CITY OF ALBUQUERQUE

**Re: Broadbent Office Park Bldg C, Grading and Drainage Plan
2611 Broadbent NE
Engineer's Stamp dated 12/08/08 (H-15/D040H)**

RE: BROADBENT OFFICE PARK, BLDG. C (H-15 / D040H)

BLDG. C GRADING & DRAINAGE PLAN

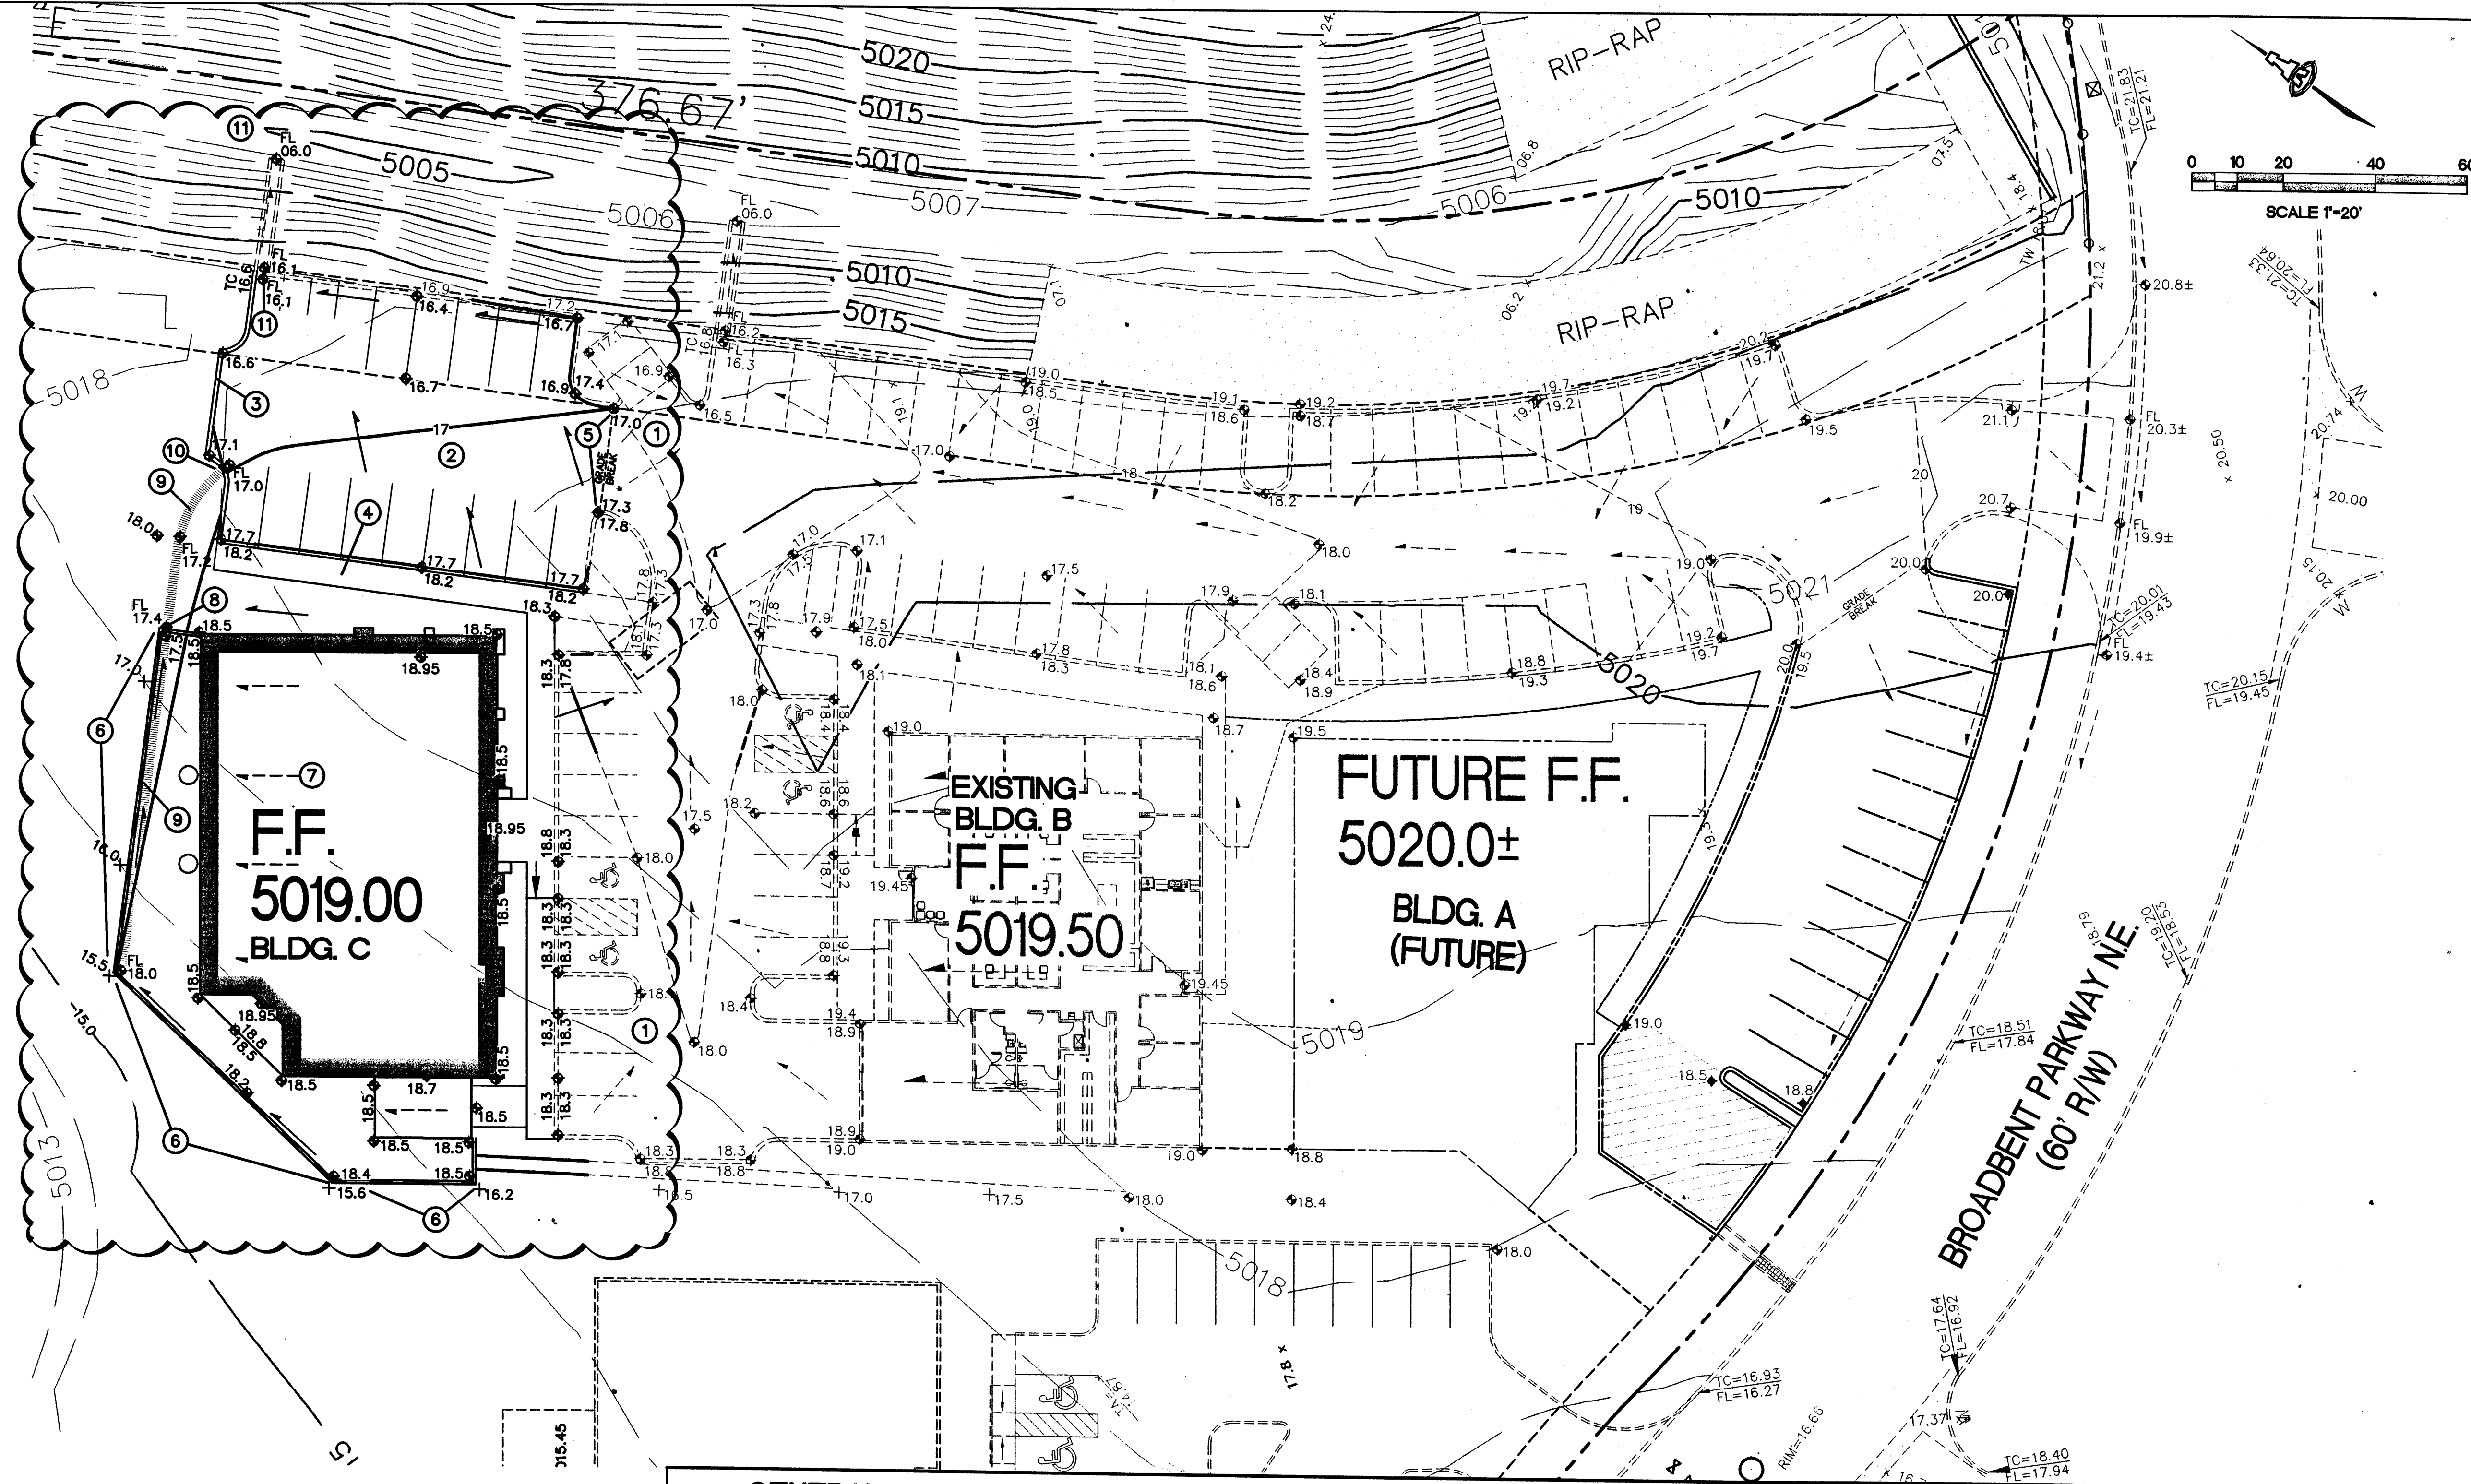
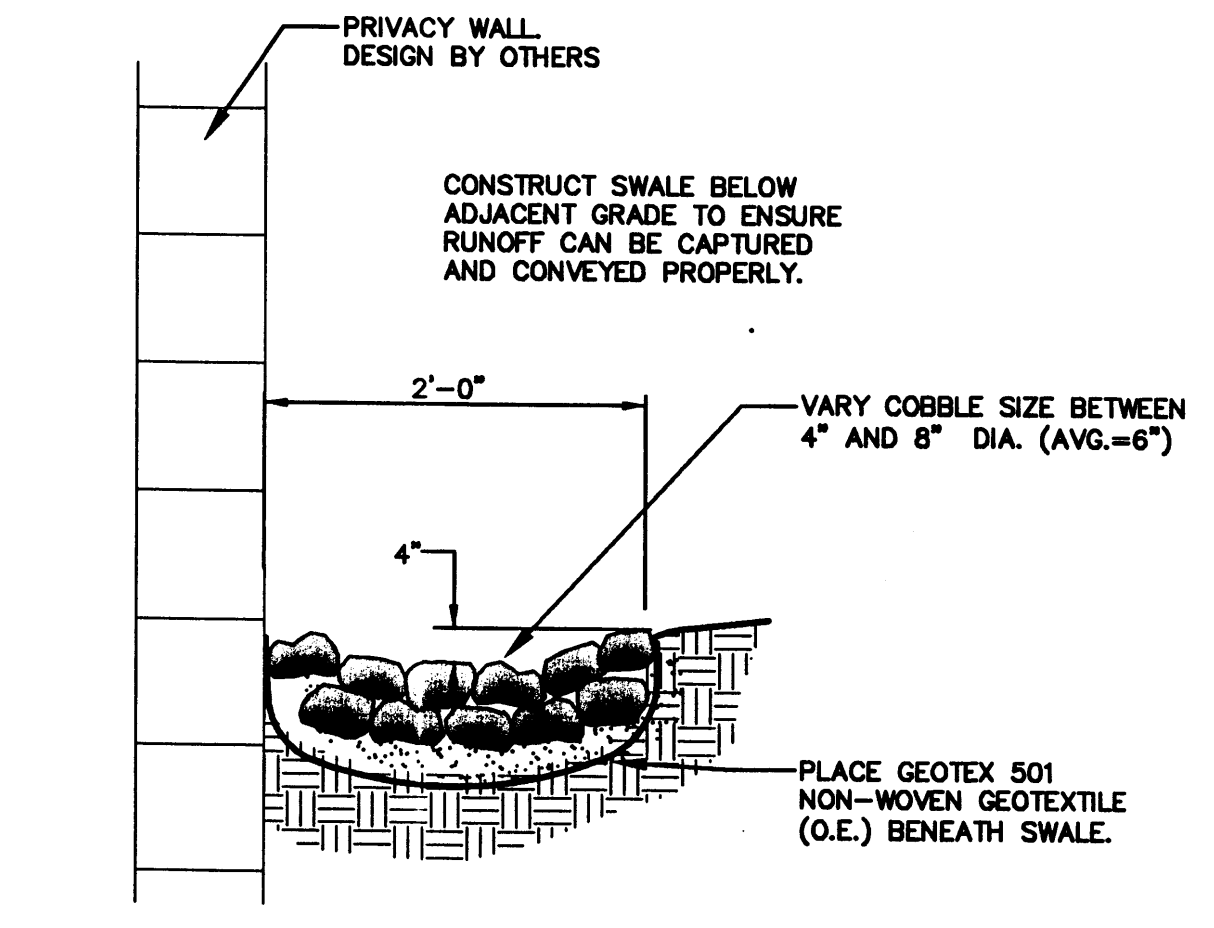
- Please provide details for proposed wall opening (16"X8" – note 8) and 2' wide fractured face rip-rap swale (note 9).

- Detail provided for fractured face cobble swale.
- Keyed Note #8 revised to specify turned concrete block or two 6" dia. pipes through wall rather than 16"x8" high opening. Note: basin will generate approx. 0.8 cfs during a 100-year, 6-hour storm. Capacity of each opening using the orifice equation ($h=0.75'$) is approx. 0.8 cfs for a total capacity of approx. 1.6 cfs.
